7 June 2010

**ROYAL REHABILITATION CENTRE SYDNEY SITE, 600 VICTORIA ROAD, RYDE
AMENDED SECTION 75W MODIFICATION OF THE MINISTER'S APPROVAL FOR
TORRENS TITLE SUBDIVISION (MAJOR PROJECT NO. 07_0100)**

DIAGRAM 3
(SCALE 1:500)

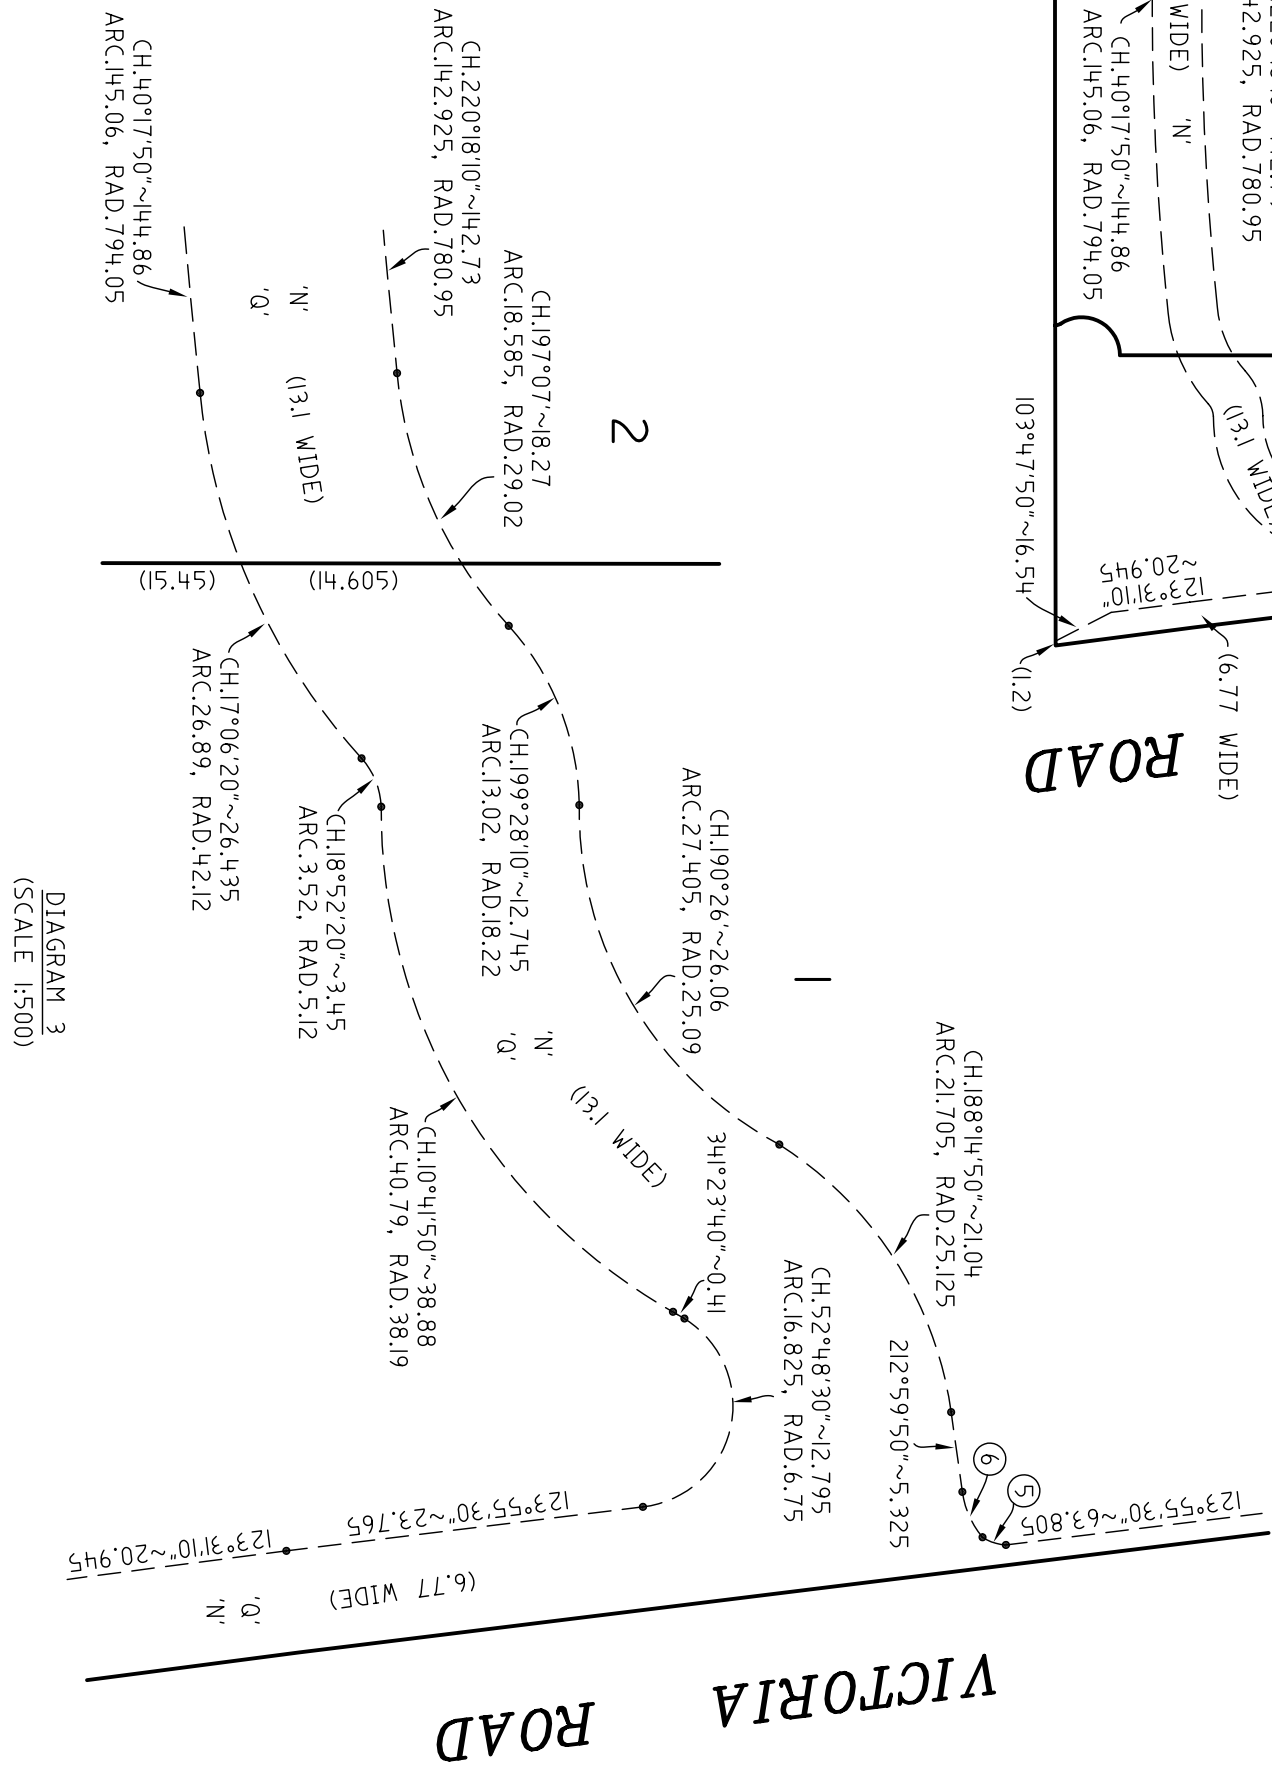
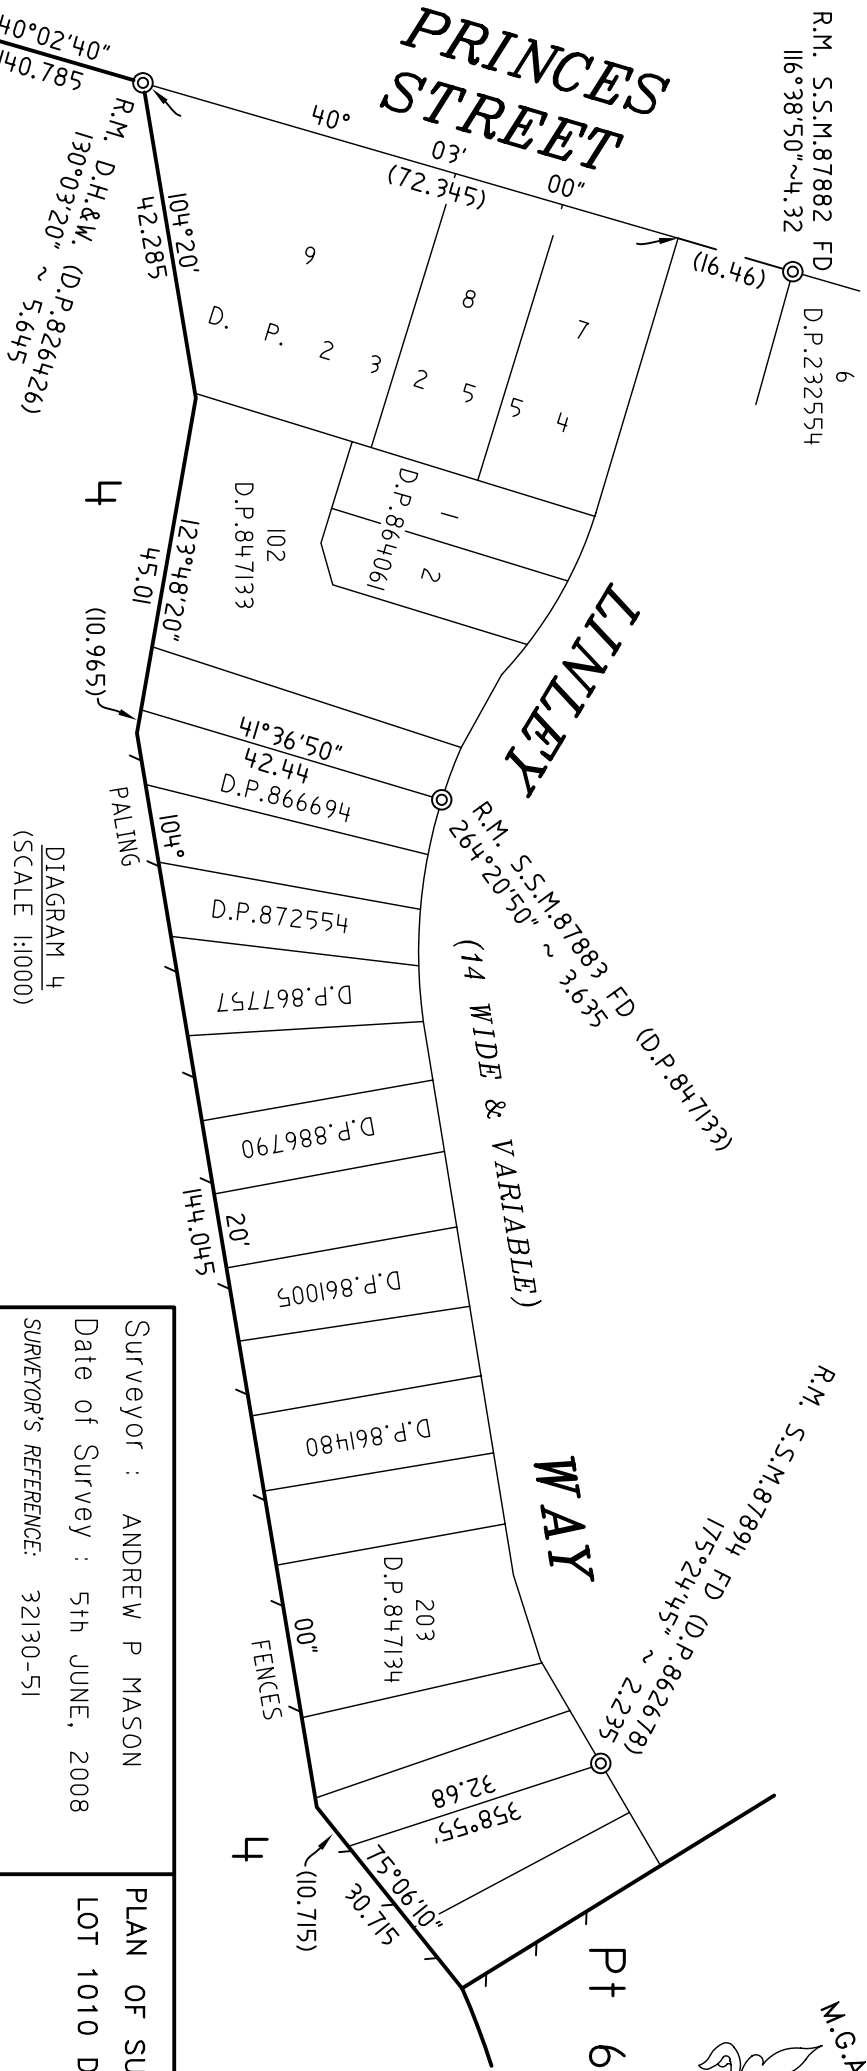
1. At the north-western narrow section of approved Lot 3 and approved Pt Lot 6 (respectively renamed Lot 8 and Lot 9 in the Modified Subdivision Plan in accordance with Land Title Office requirements for consecutive numbering of lots). The discrepancies between the two plans arise from the fact that the Approved Subdivision Plan shows an angled boundary at the north-western end of what was previously Lot 3, at the point where it adjoins what was previously Pt Lot 6. In contrast, the Zoning Map shows a sharp right angled corner at this point. The width of the north-western handle to previous Lot 3 has also be narrowed to match the Zoning Map.

2. The boundary between the previous Lot 3 and Pt Lot 6 on the eastern side of the parkland area. The boundary on the Approved Subdivision Plan shows a sharp change in direction, whereas the boundary on the Zoning Map curves around the south eastern side of the parkland area.

The Modified Subdivision Plan (**Attachment 3**) seeks to amend the Approved Subdivision Plan in respect of both of these discrepancies, in order to ensure that it is more in line with

the Zoning Map and Concept Plan Approval. As illustrated by the overlay of the Zoning Map and Modified Subdivision Plan (**Attachment 4**), the two plans are now aligned.
